From: [REDACTED]
Sent:
To: Amber Willard
Cc: 'Sarah Mitchell'; 'Mark Mitchell'
Subject: Your ref: BN/112/21PL Land Adjacent to 14 Stoneyfields Cottages
Attachments: MITCHELL 01P REV B PLAN SHOWING NEW DWELLING.pdf

Please find attached revised drawing 01P Rev B noting the correct species of the trees adjacent to the site.

FOR MR & MRS MITCHELL		
SITE SITE AT: STONEFIELD NURSERY, EASTERGATE LANE, EASTERGATE. PO20 3SL		
TITLE SITE PLAN SHOWING PROPOSED DWELLING		
SCALE 1:100 © A2	DATE 03/22	DRAWING NO. 01P REV C

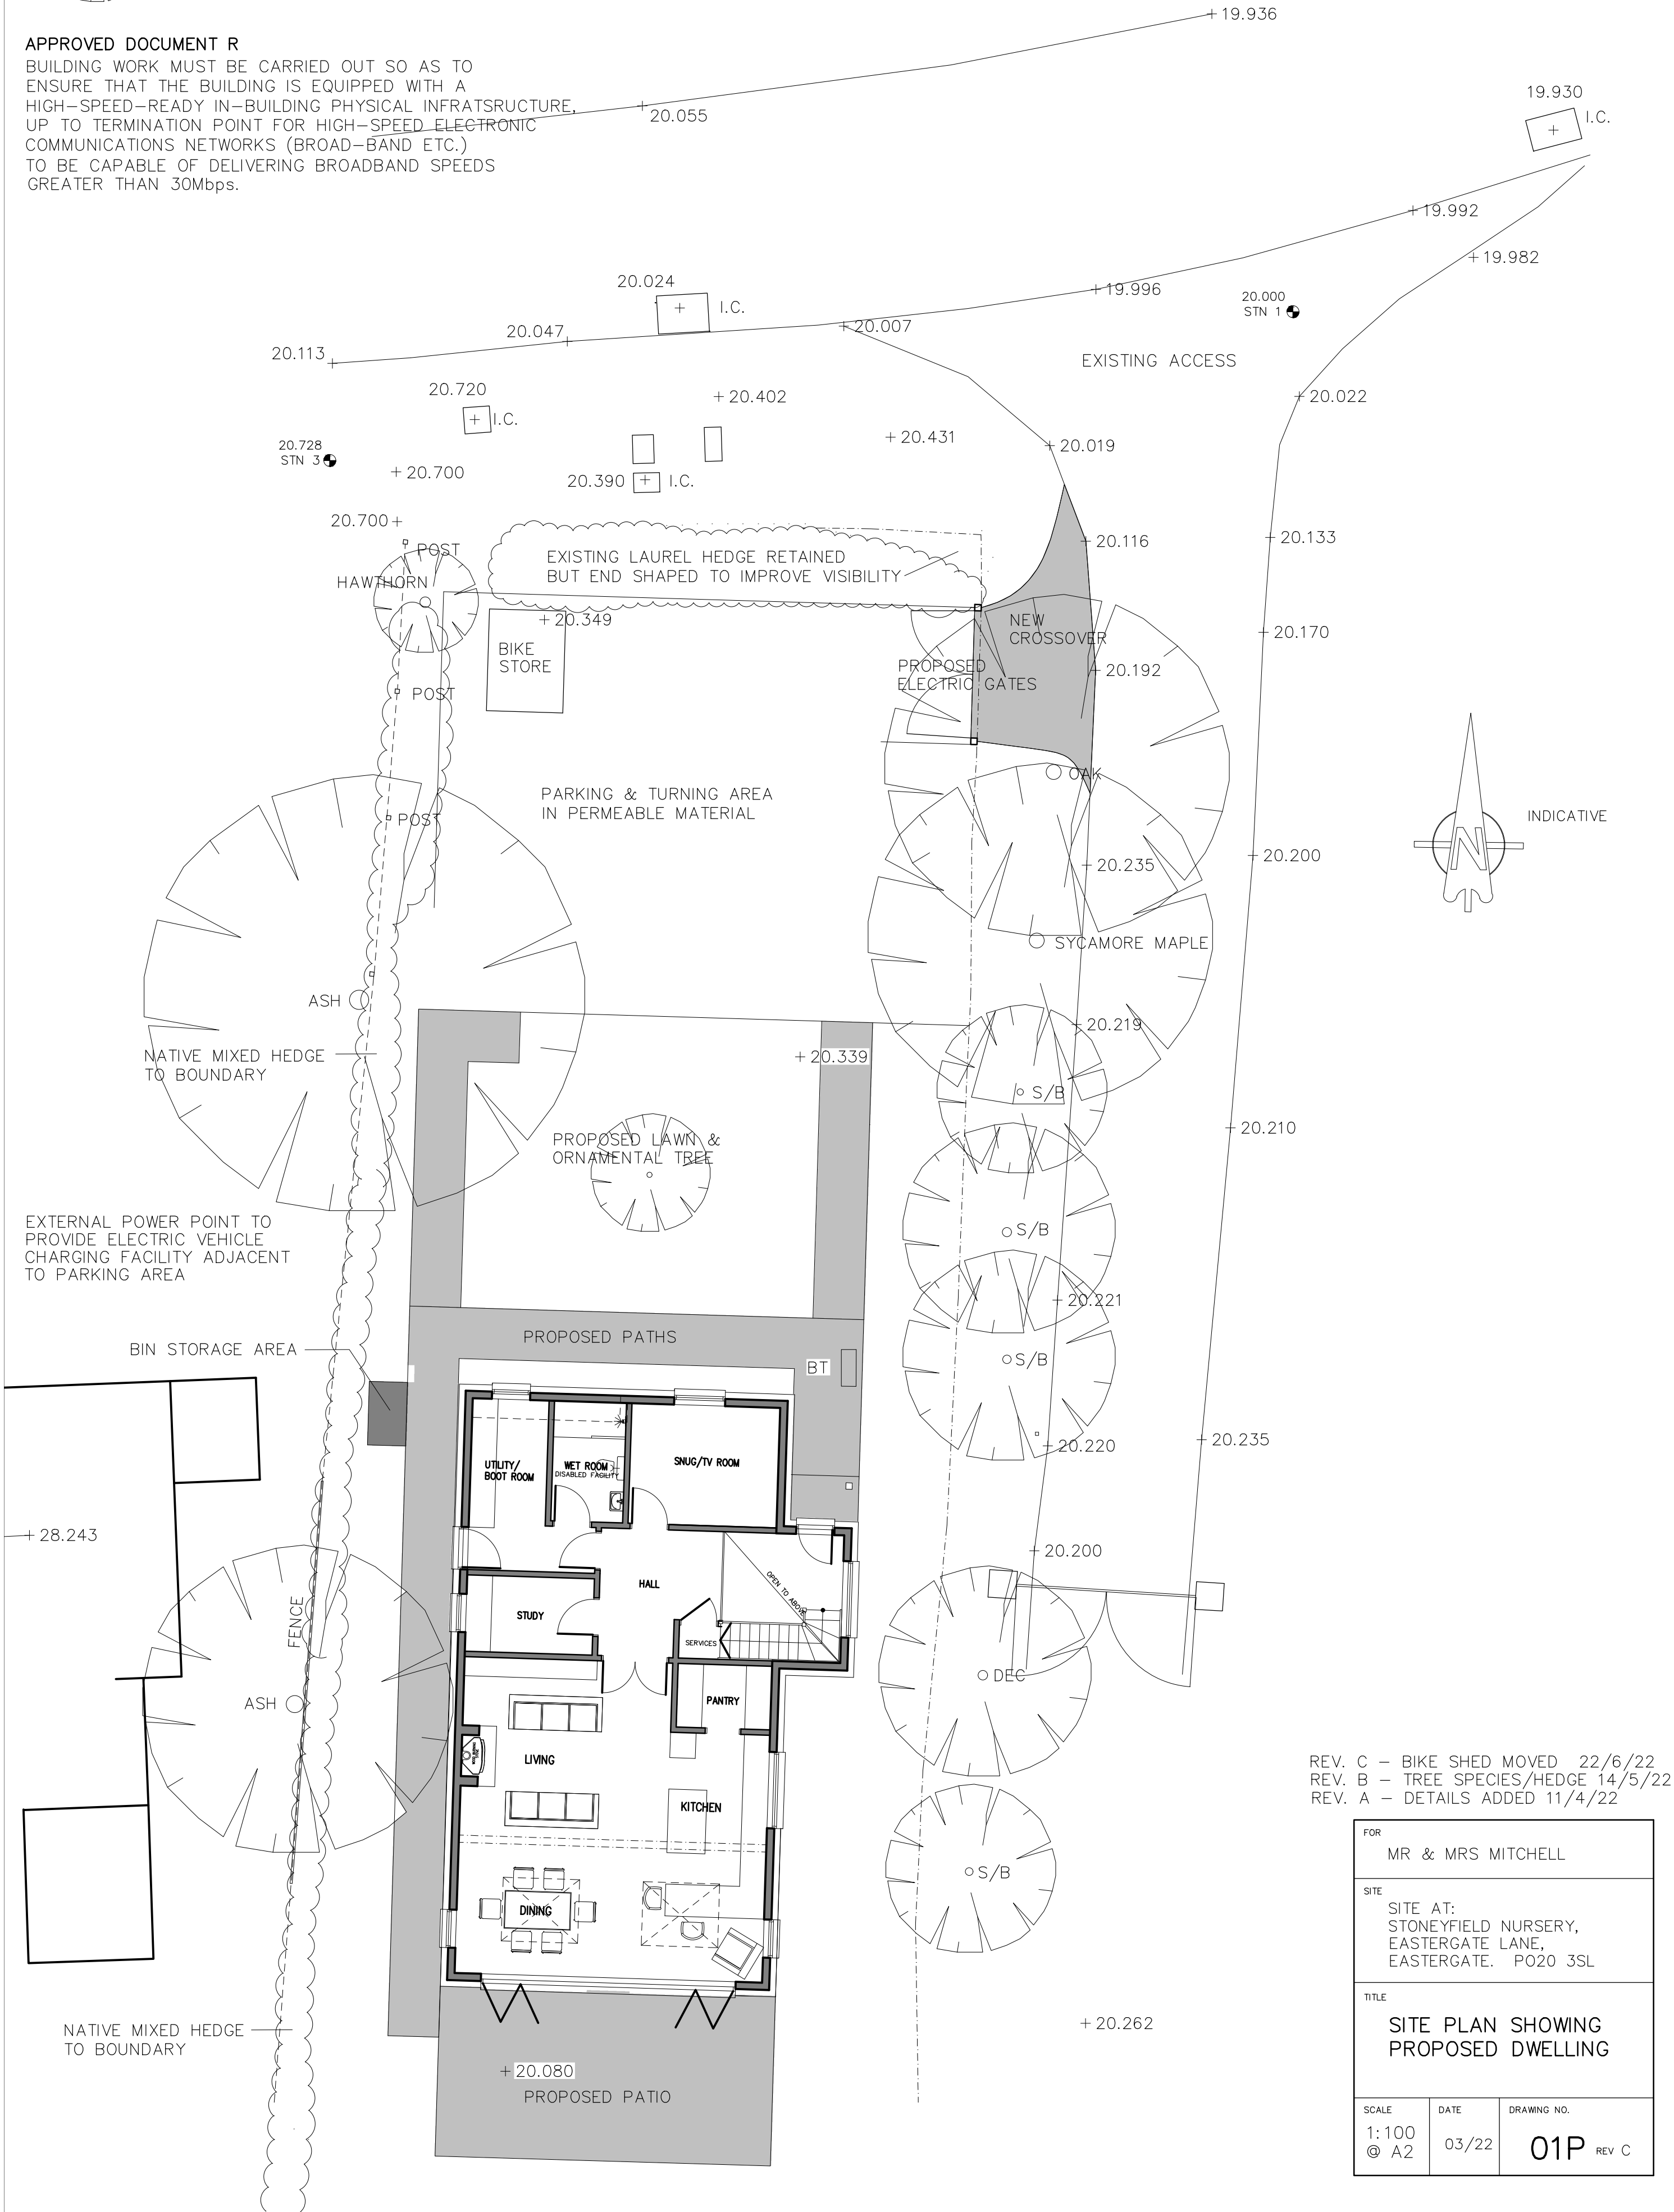
I have also added a note regarding the existing laurel hedge on the frontage of the site stating that 'the end will be shaped to improve visibility to the public highway'.
